Our ref: J212

**Re: DA 177-8-2004 MOD 2 - Locomotive Refuelling Facility for QR National - Alterations to Development Application**

Attached: Revised General Arrangement of Refuelling Station - Parsons Brinckerhoff - 003REVD

PLAN ON REFUELLING STATION

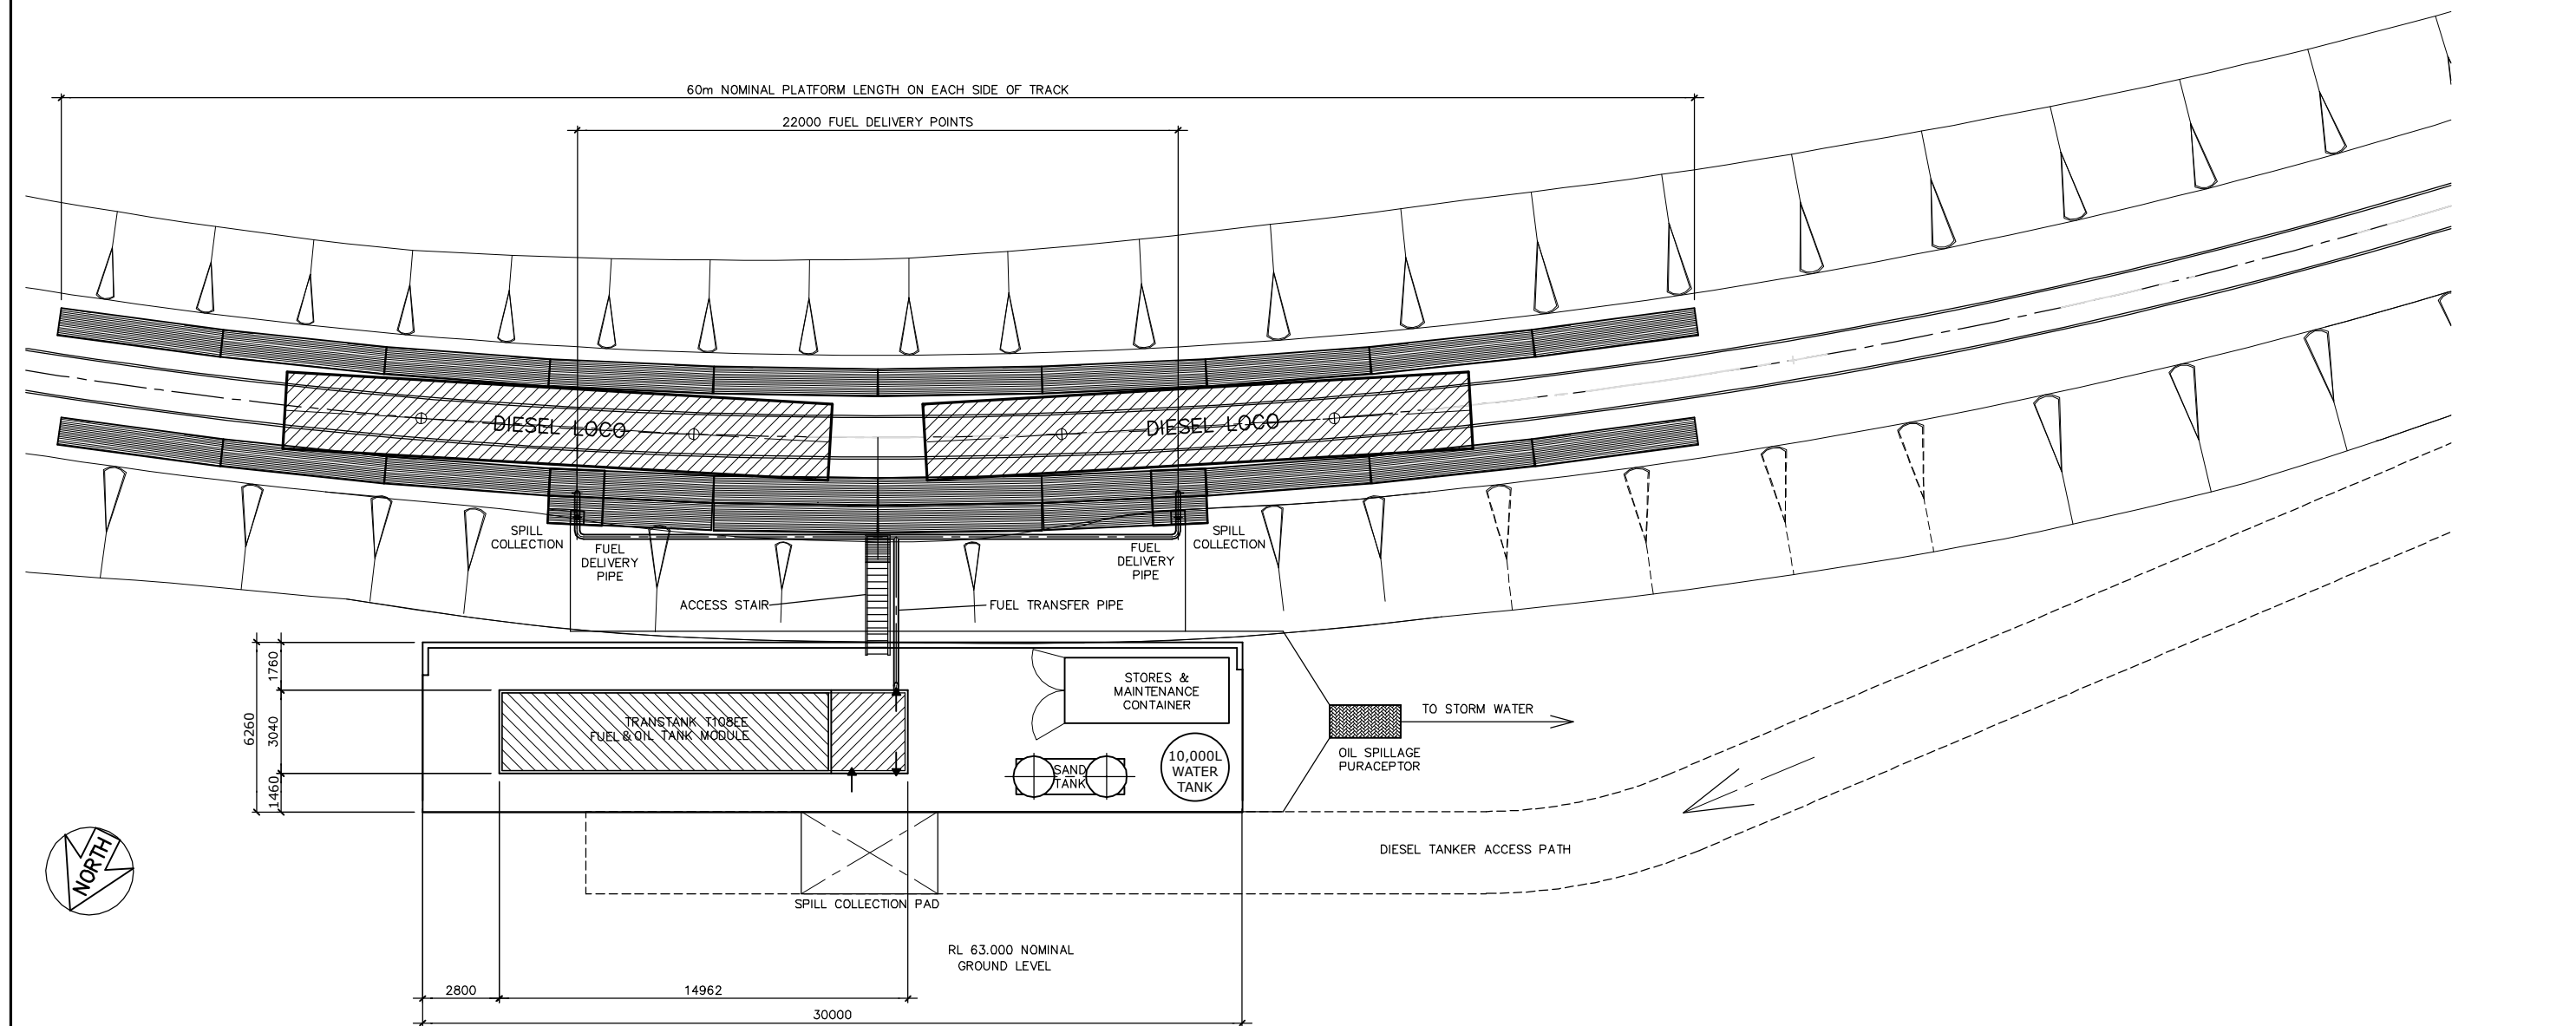
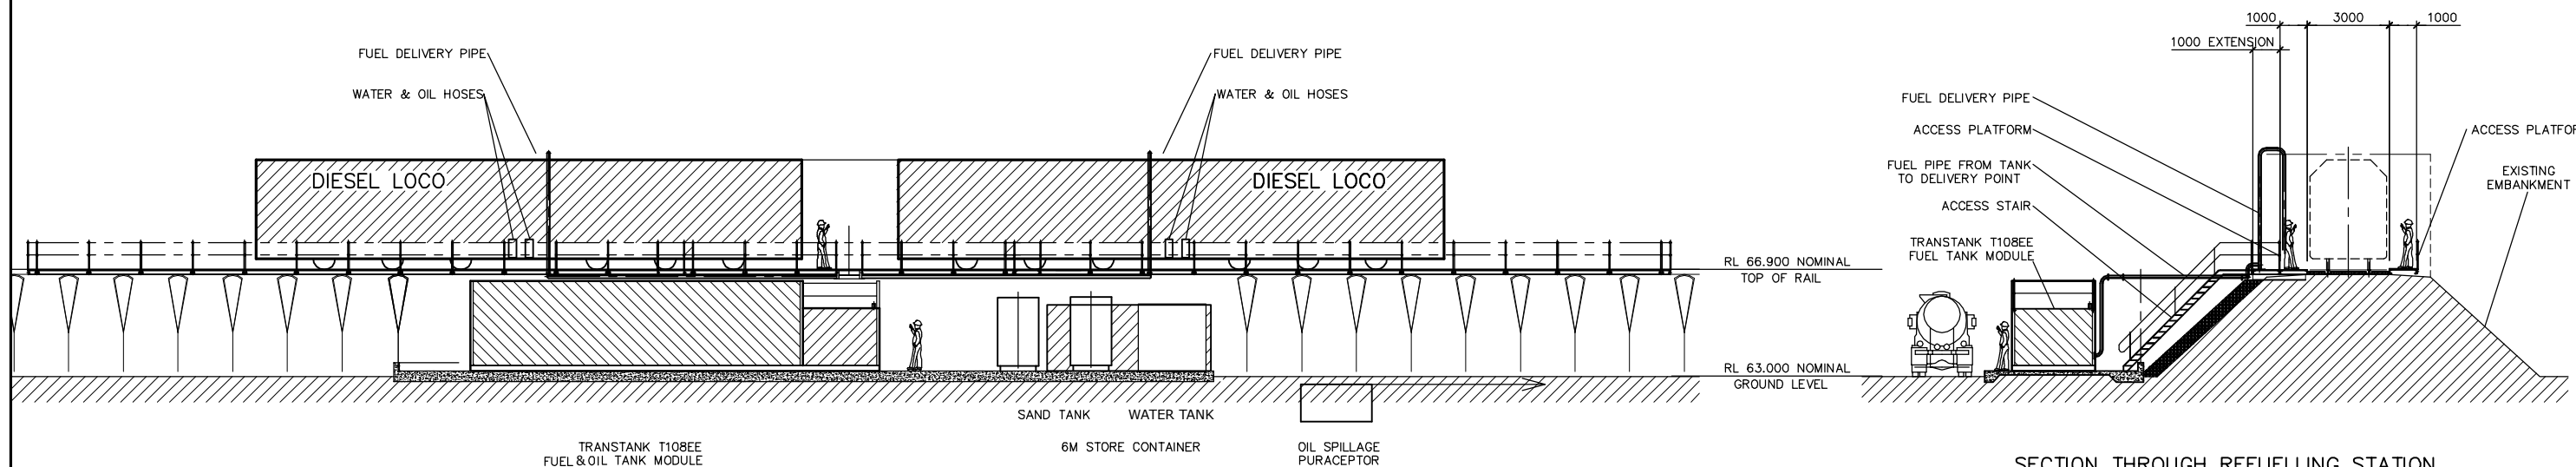
Three small shelters are proposed to be constructed on the refuelling platform, these shelters (referred to as "skids" on the attached plans) are approximately 2 to 2.4m high and 3 to 4m wide and would be clad in *River Gum Green* cladding consistent with the other infrastructure.

The shelters are low in profile (refer to elevation drawings where train height is approximately 4m), and will provide protection from the elements for train drivers refuelling the locomotives. The low profile shelters will provide an opportunity to further shield lighting and refuelling activities on the site from the Golden Highway. At the site inspection it was evident that the shelter would be barely visible from the Golden Highway due to the dense mid-canopy of the smaller eucalypts and acacia.

Since the project application, engineering design of the facility has also further advanced resulting in minor changes to the layout of the facility and modification of the sand delivery system. Changes to the sand delivery system have included the an additional set of two eight tonne pneumatic sand storage tanks and small one tonne fixed sand pots on the refuelling platform. The rate of sand use and external delivery rates will remain consistent with that stated in the SEE. There are no significant changes to the overall location and footprint of the facility.

An updated site plan including the shelters (or skids) and additional sand tanks is attached.
